**Memorandum
 Planning and Urban Development Department
 Planning Division**

To: Chair Morrisette and Members of the Portland Planning Board
From: Jean Fraser, Planner
Date: December 13th, 2013
Re: **December 17th, 2013 Planning Board Workshop**
 Level III Site Plan and Subdivision:
 14 unit residential and commercial condominium, 118 Congress Street
 "118 on Munjoy Hill"
 118 Condominiums, LLC (Ed Theriault), Applicant

LANDSCAPE PLAN
SCALE: 1" = 8'-0"

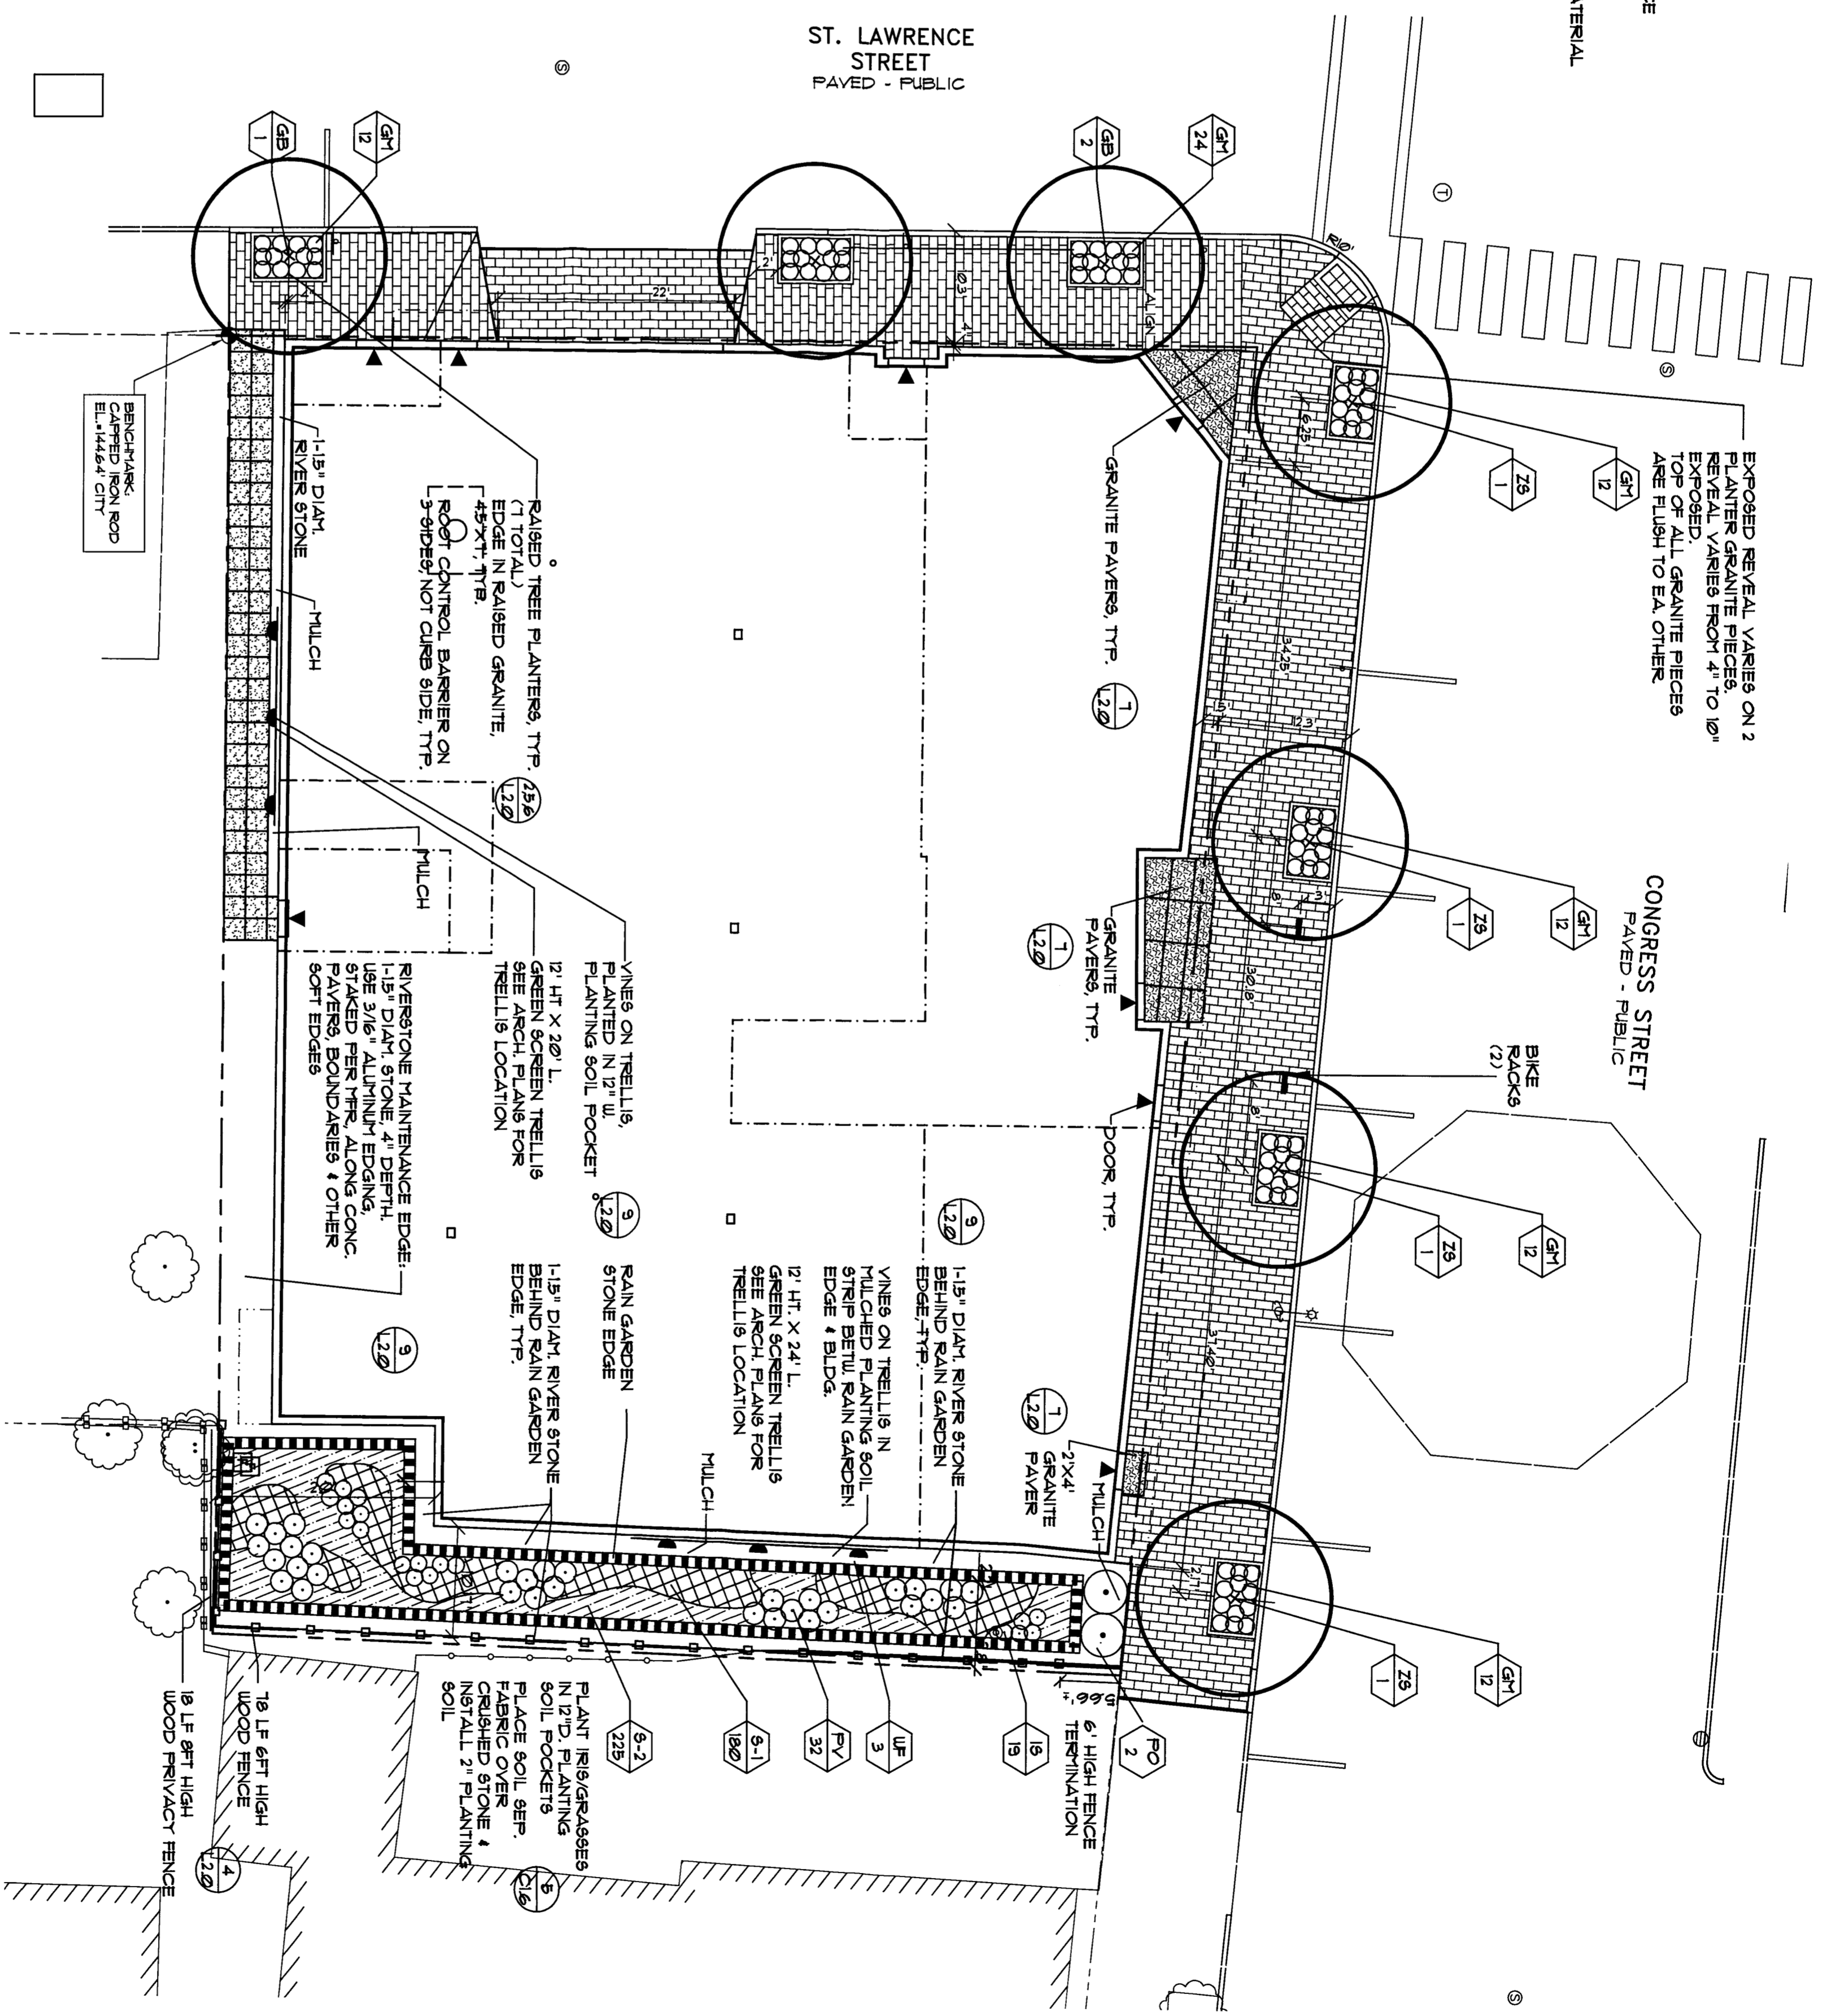
The subdivision requirement would be one tree per unit, or 14 street trees, in or near the ROW. There are already 4 street trees, which are proposed to be removed and replaced with 5 street trees. The City Arborist is very concerned at the impact on the existing street trees and comments (Attachment 6):

The size and mass of the proposed development with overhangs obscures significant streetscape and overwhelms the historic views of traditional Congress Street. The lack of any landscape greening, planters, and removing available space for street trees is like no other project in recent memory.

** The existing mature street-trees have high value, especially on the Waterville Street side. Continuing the street tree canopy along Congress Street is a high priority. The project as proposed severely reduces the street tree value along Congress Street & Waterville Street. Reducing tree space is counter to over 20 years of greening efforts and street tree planting in the Munjoy Hill, CDBG area.*

** Proposed building overhang over the sidewalk seriously effect street-tree growth and are strongly opposed as shown. The building overhang eliminates ALL future shade tree / street tree possibilities and is unacceptable as it changes the character of Congress Street and the Eastern Promenade.*

The project also requires an additional 9 street trees or equivalent contribution to the Street Tree Fund.

1 NORTH ELEVATION
1/8" = 1'-0"

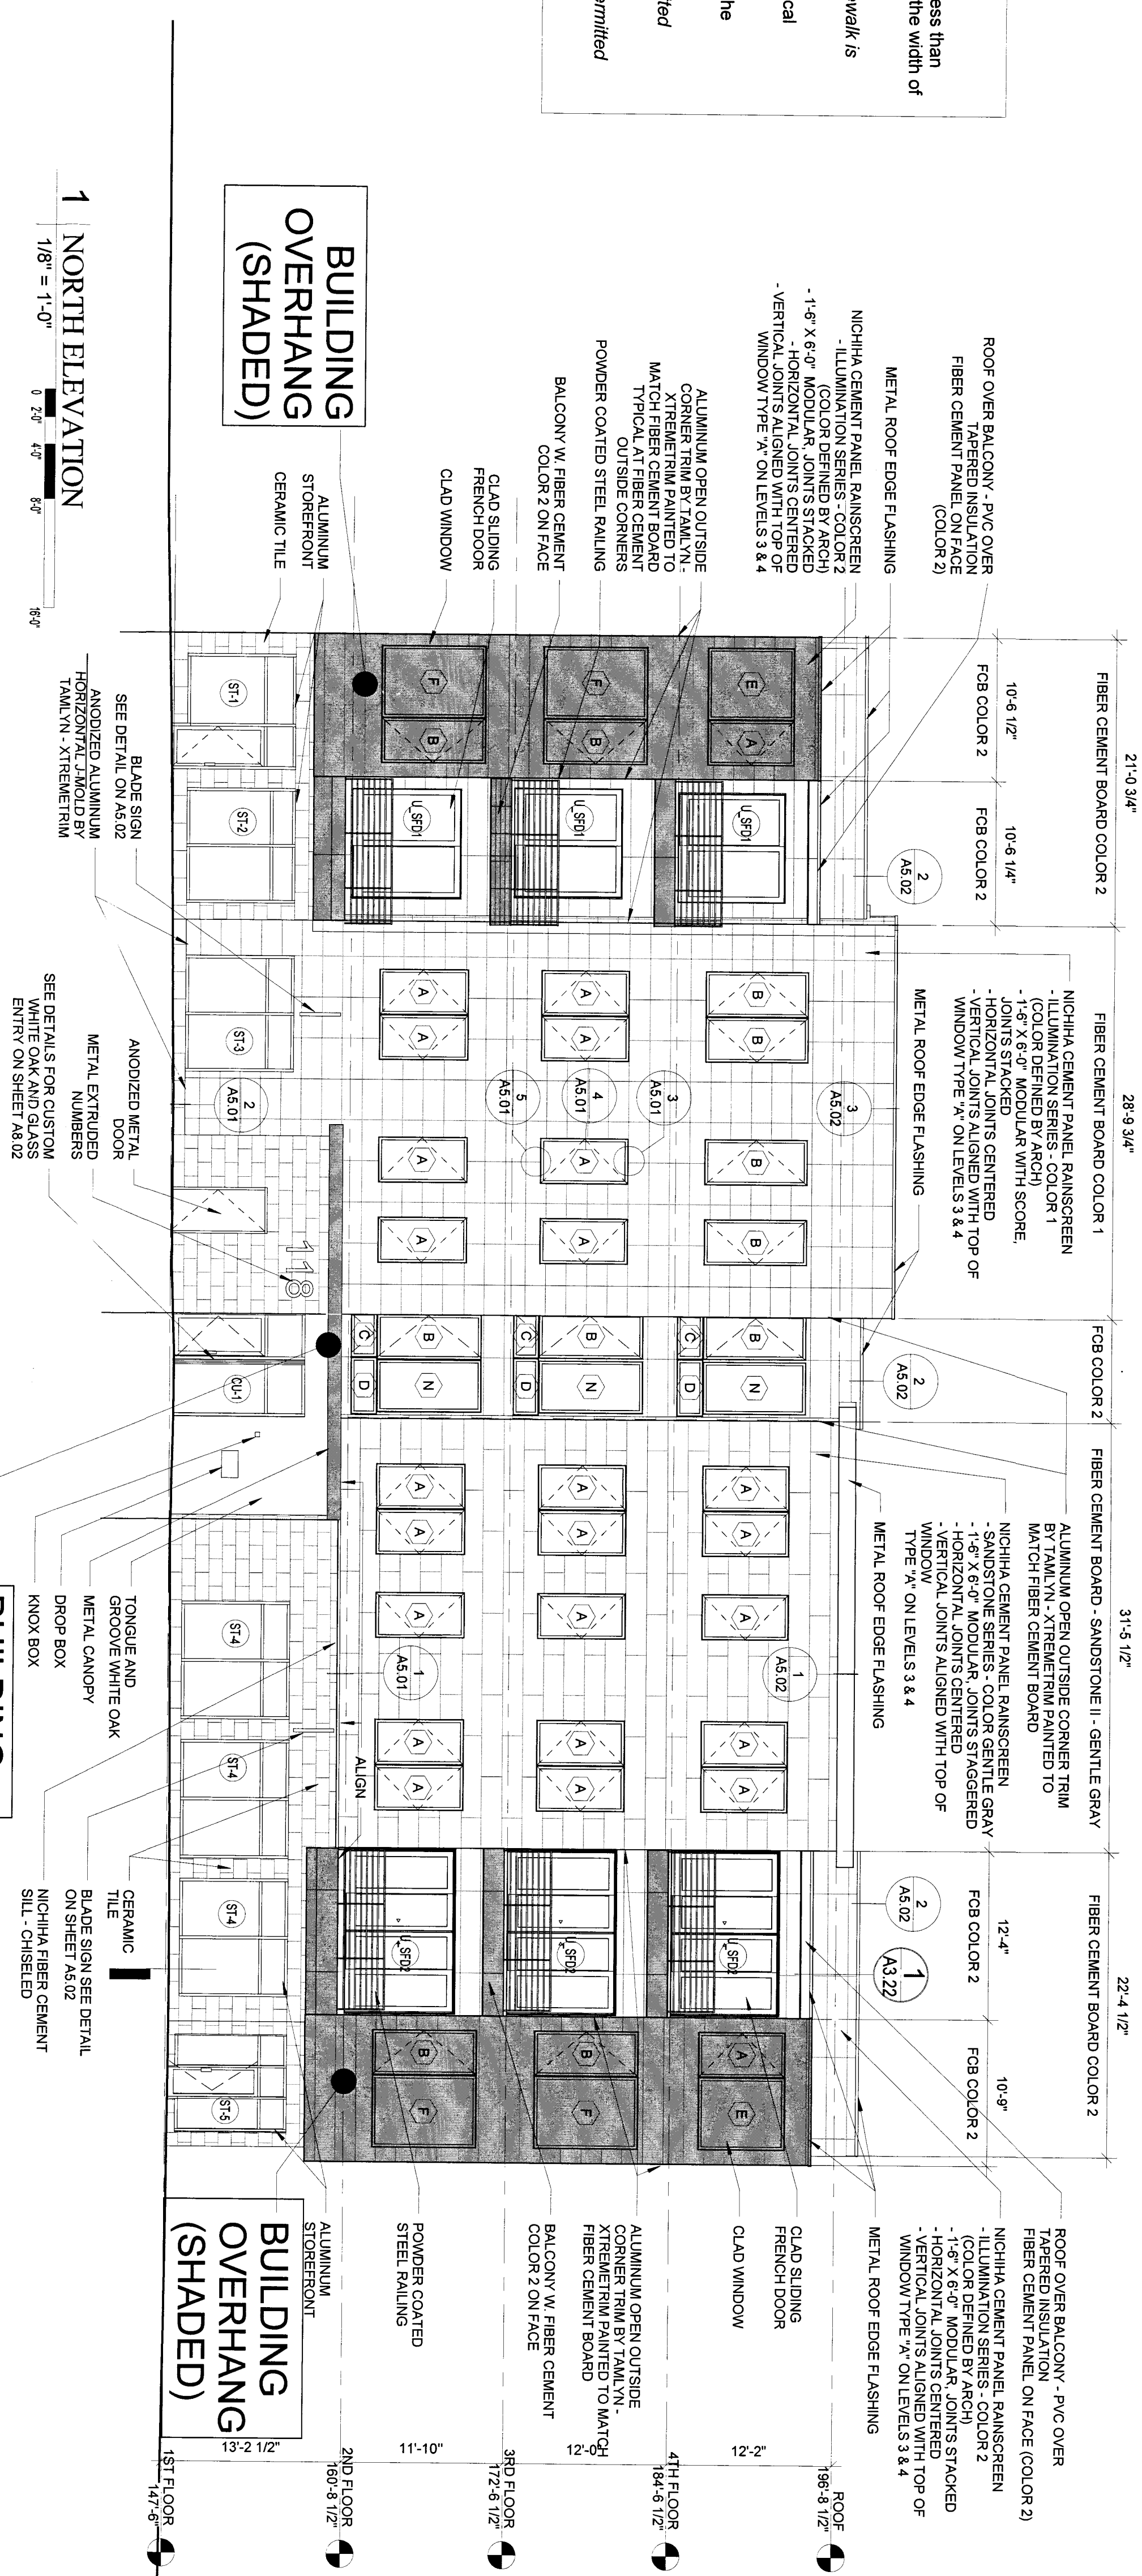
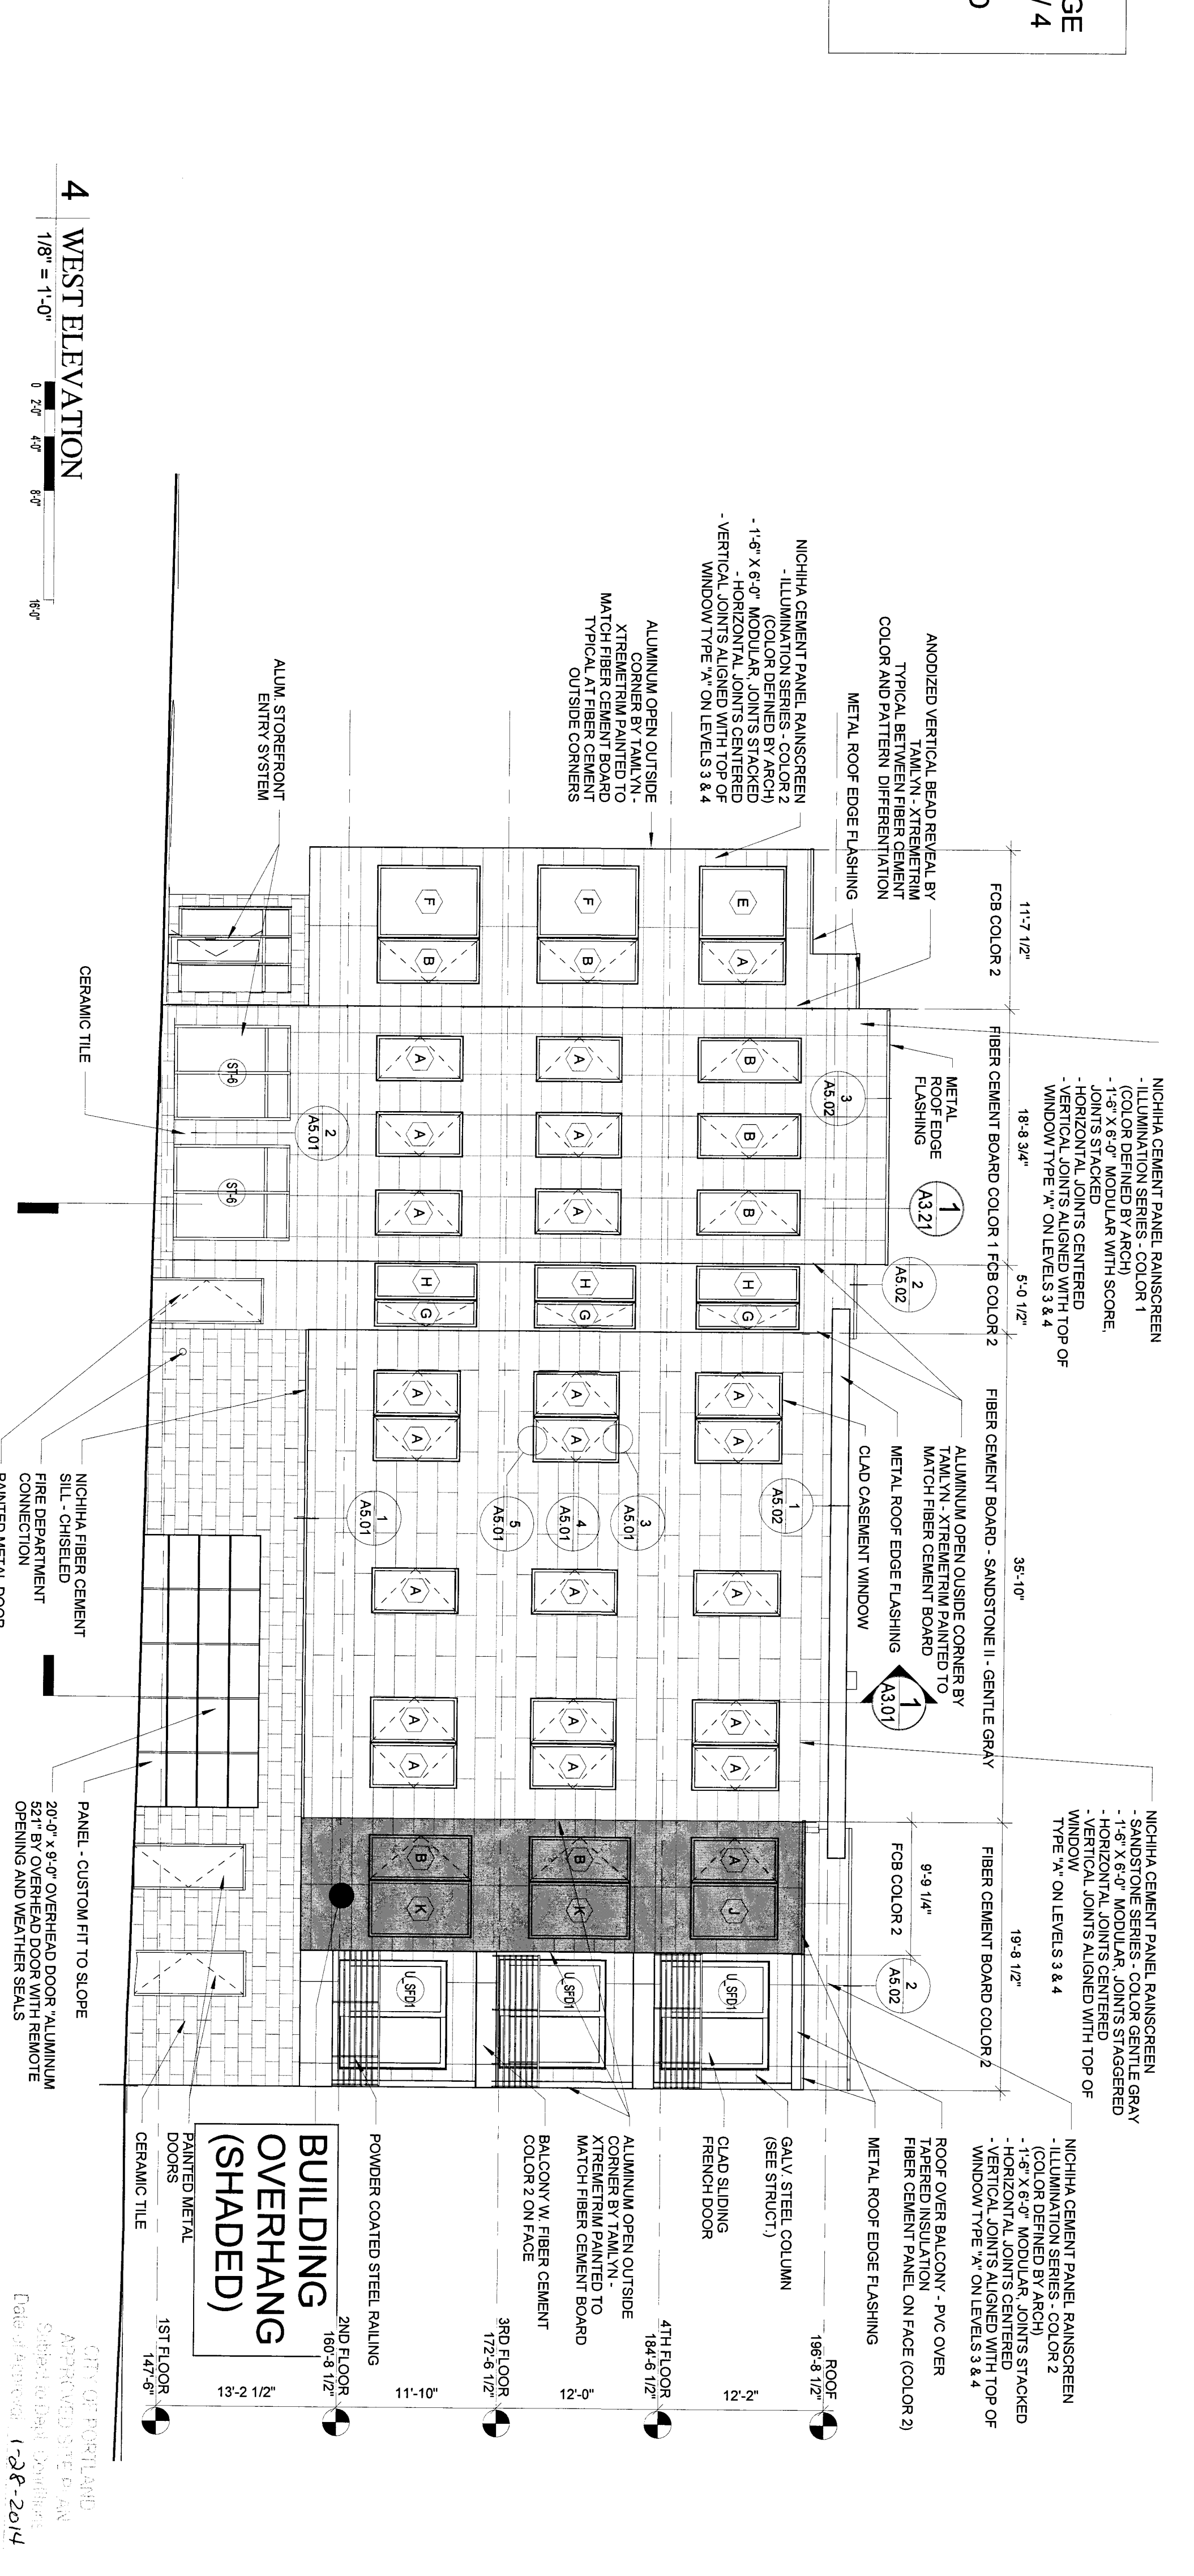
A key concern is that there are 12 places (each about 20 feet long) where the building overhangs the ROW. The depth of the overhangs varies between 2'4" and 2'6" with a clearance over the sidewalk of about 10 feet for Congress Street and 12 feet for St Lawrence Street (see Plan 16). DPS comment (Attachment 4):

- 1. The proposed areas encroaching into the Congress and St Lawrence St right of way are excessive and should be scaled back or the building should be set back to accommodate these features. Falling ice and snow is a pedestrian safety issue.*

The City Arborist also is concerned about the overhangs in terms of the impact on street trees and views (Attachment 6), and the Urban Designer notes that there is no compelling reason (eg site constraints or to maintain historic character) why the building can not be set back so that the balconies are within the property line (Attachment 7).
